From: Alistair Walker [REDACTED]
Sent: 24 July 2017 18:43
To: Sue Howell
Cc: Anita Gardner; [REDACTED] Nic Bryant
Subject: RE: 5312_Littlehampton Leisure Centre

Further to our discussions regarding the landscape design for the Littlehampton Leisure Centre, I have updated all softworks drawings and specification to respond to your comments outlined in the email below.

Subject: 5312_Littlehampton Leisure Centre

D05
5312
406
TYPICAL PLANTING DETAIL: WOODLAND MATRIX
SCALE 1 : 50

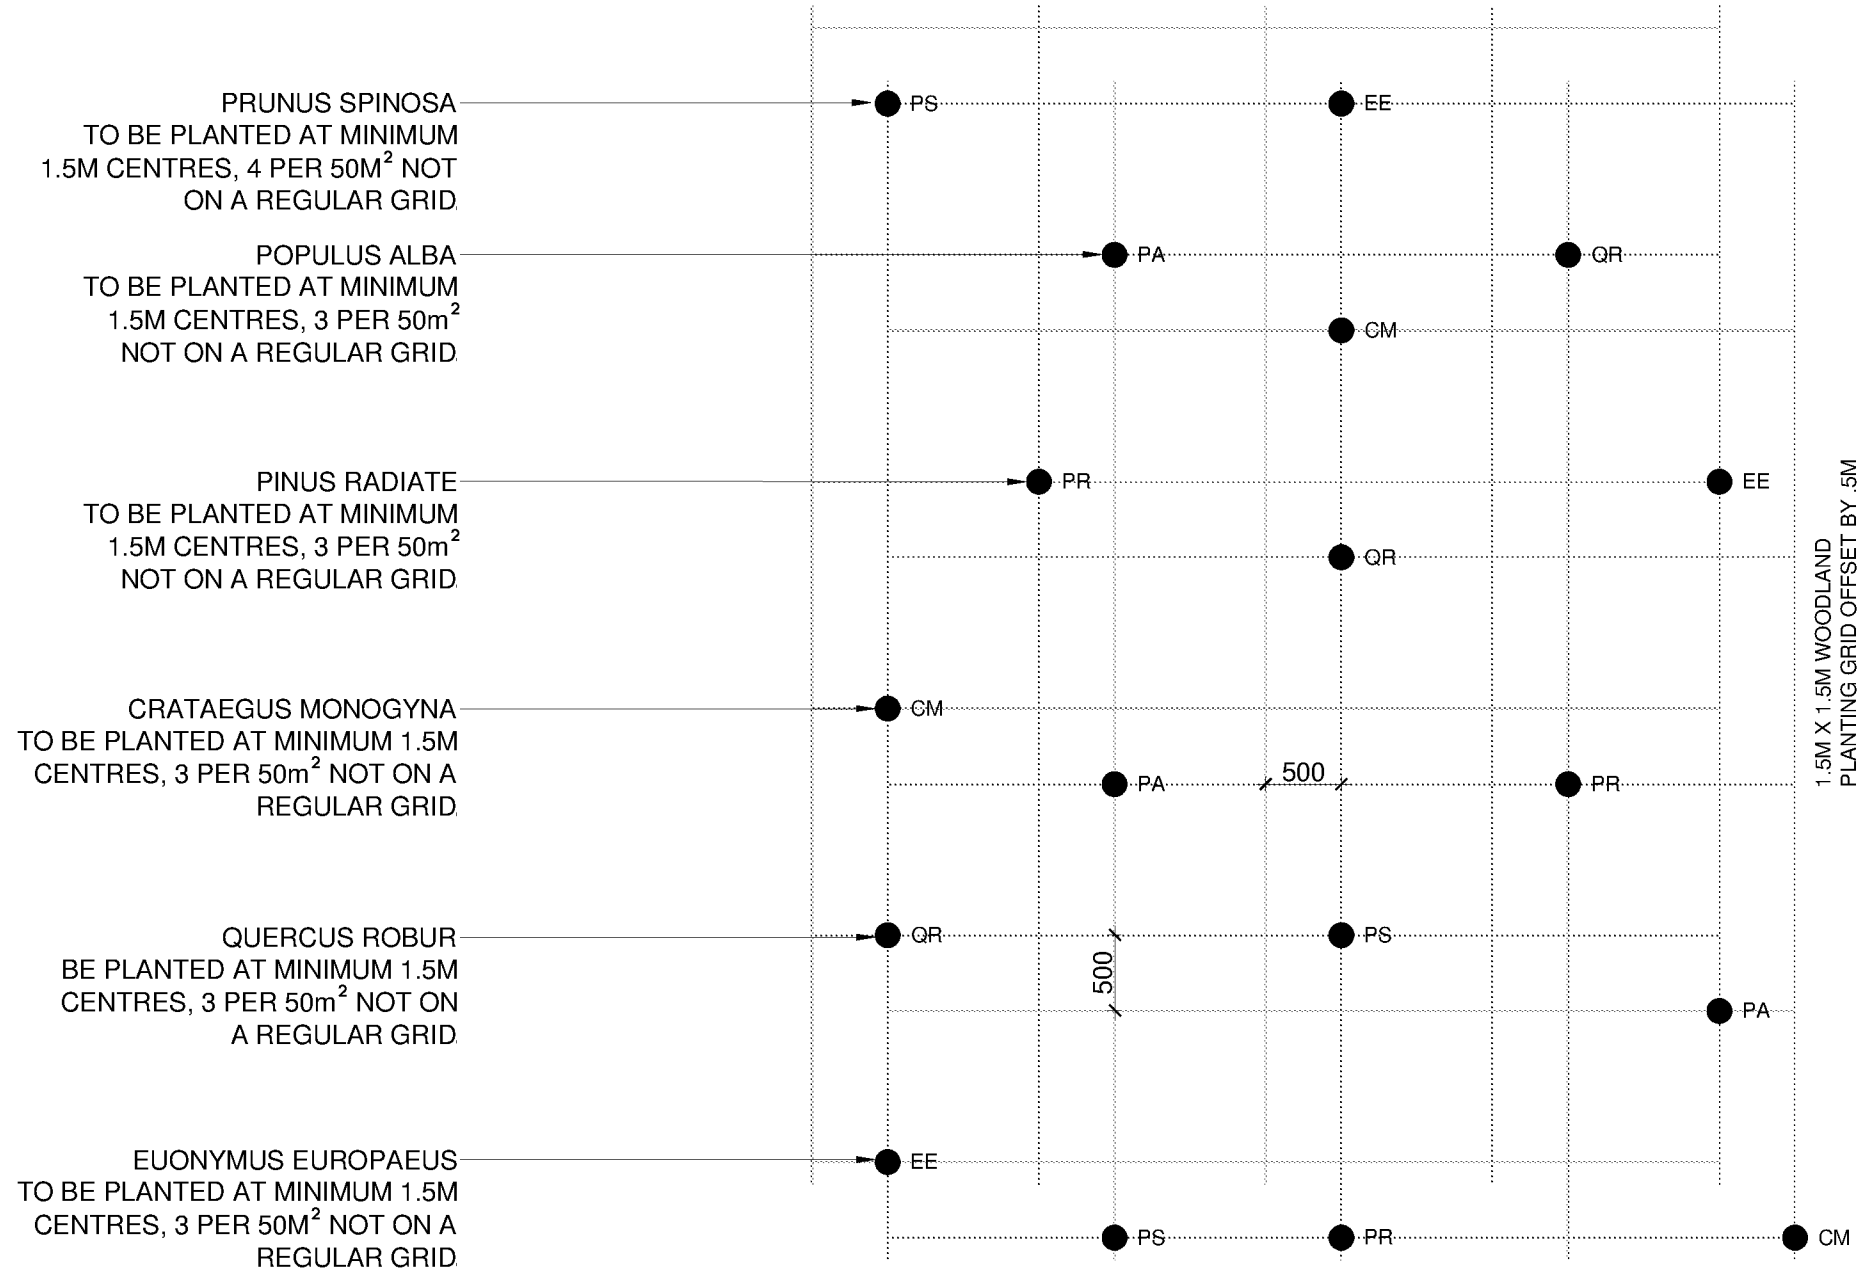
- Species rich grassland mix (EM10 – TUSSOCK MIXTURE) shown on 5312_LC_405 and also specified with 5312_LC_901 Softworks Specification.
- Compensatory woodland planting is detailed in 5312_LC_406

DWG. NO 5312_LC_103

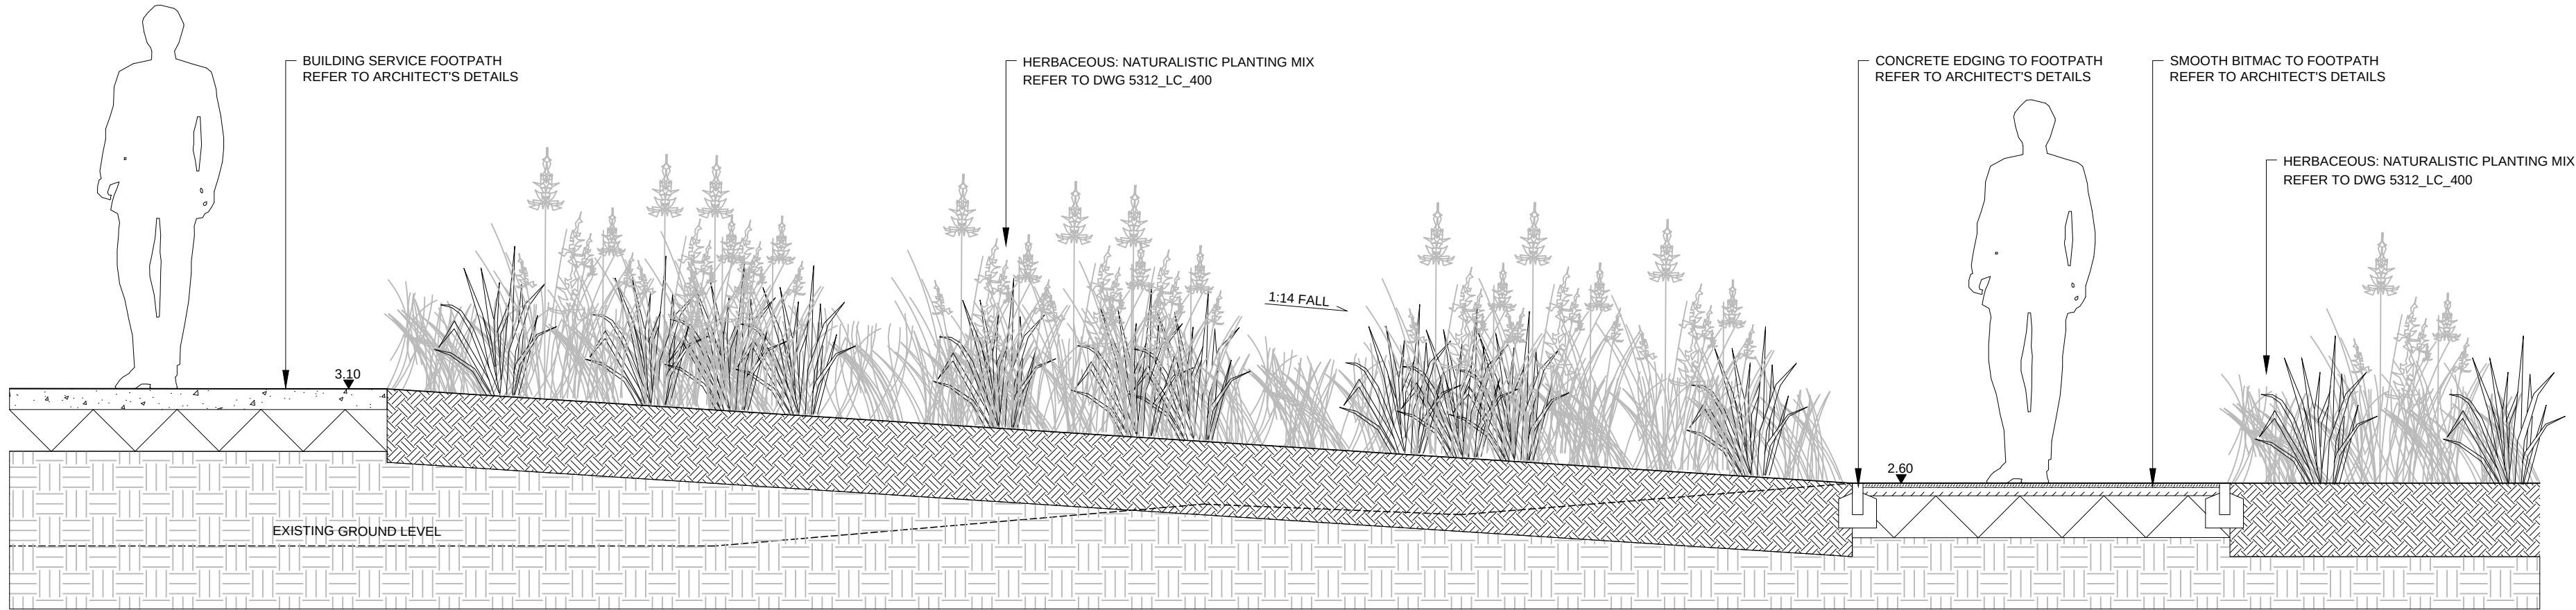
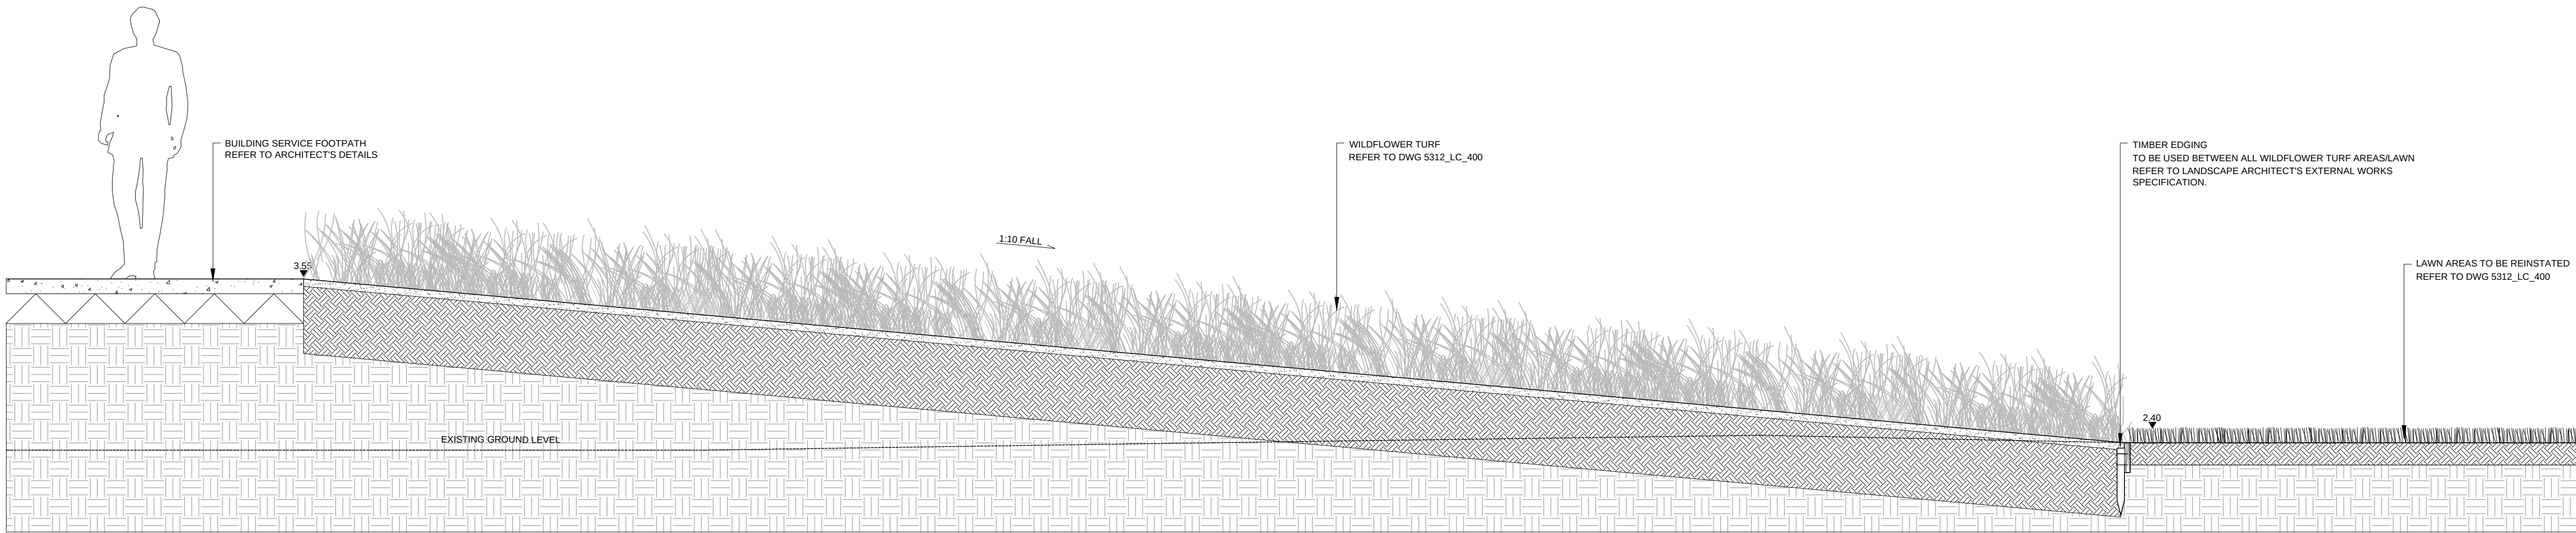
- Area to the north of the Leisure Centre – Whilst there are informal paths within the existing woodland it was our intention not to rationalise these routes and leave this area as natural as possible in order to retain the existing character of the woodland. The embankment sloping up towards the building will be sown with species rich grassland which is shade tolerant and will help blend the building within its natural surroundings.

DWG. NO 5312_LC_401_REVb

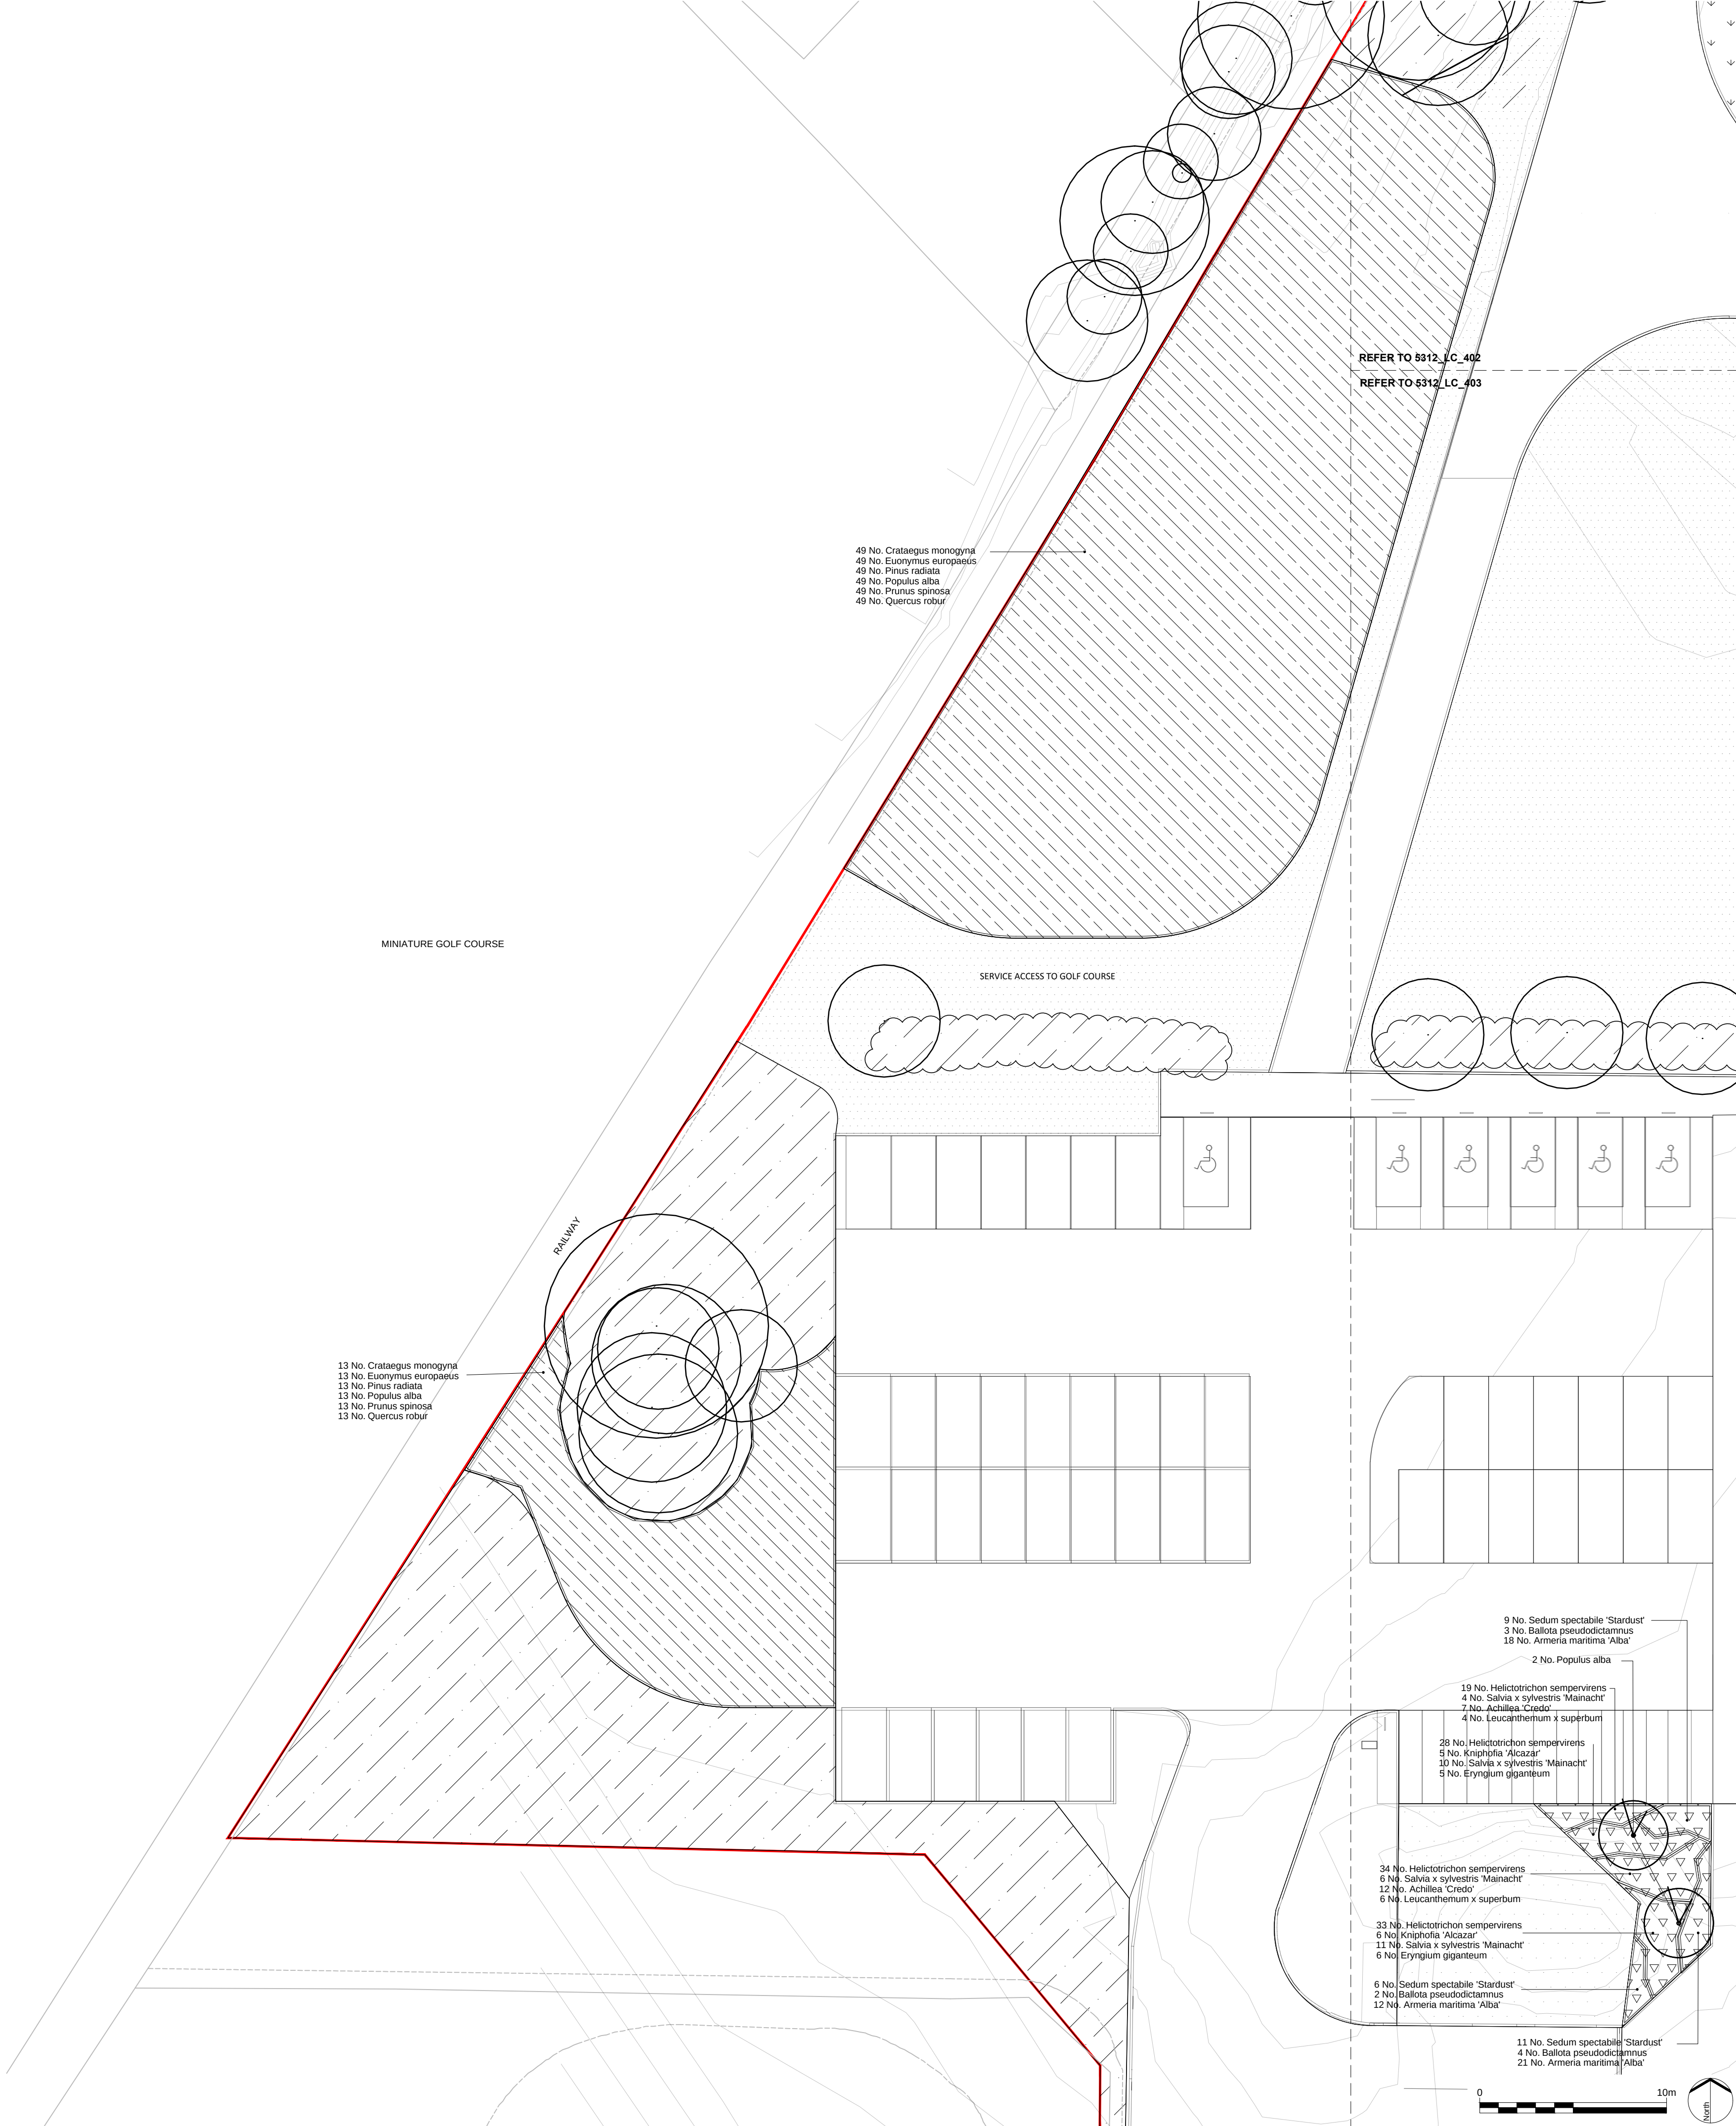
- Betula Pendula to be substituted for alternative tree species.
- Amenity grassland proposed to include "daisy lawns" – Daisy lawns were introduced in response to comments made by Arun District Council please see attached. Having spoken with the ecology consultant we feel that the current seed mix (EL1 FLOWERING LAWN SEED MIX) would be appropriate for this area under a maintenance regime that would see the grass cut to 50mm during the summer. If this is unacceptable, removing the following species from the mix would be advisable; Leucanthemum vulgare, Primula veris, Ranunculus acris and Rumex acetosa. Alternatively the areas of lawn to be reinstated could be specified as a standard lawn mix however this would have impacts on the ecological compensatory areas as you have already outlined.

- Natural Screen Planting: We are currently specified native shrubs to be "plugged" into wildflower turf. We have used this technique successfully in the past to achieve a more natural aesthetic. Again concerns regarding future maintenance are noted and this could be changed to shrubs planted within mulch.

- Betula Pendula to be substituted with Populus alba
- Decorative bark mulch added to Natural Screening Planting
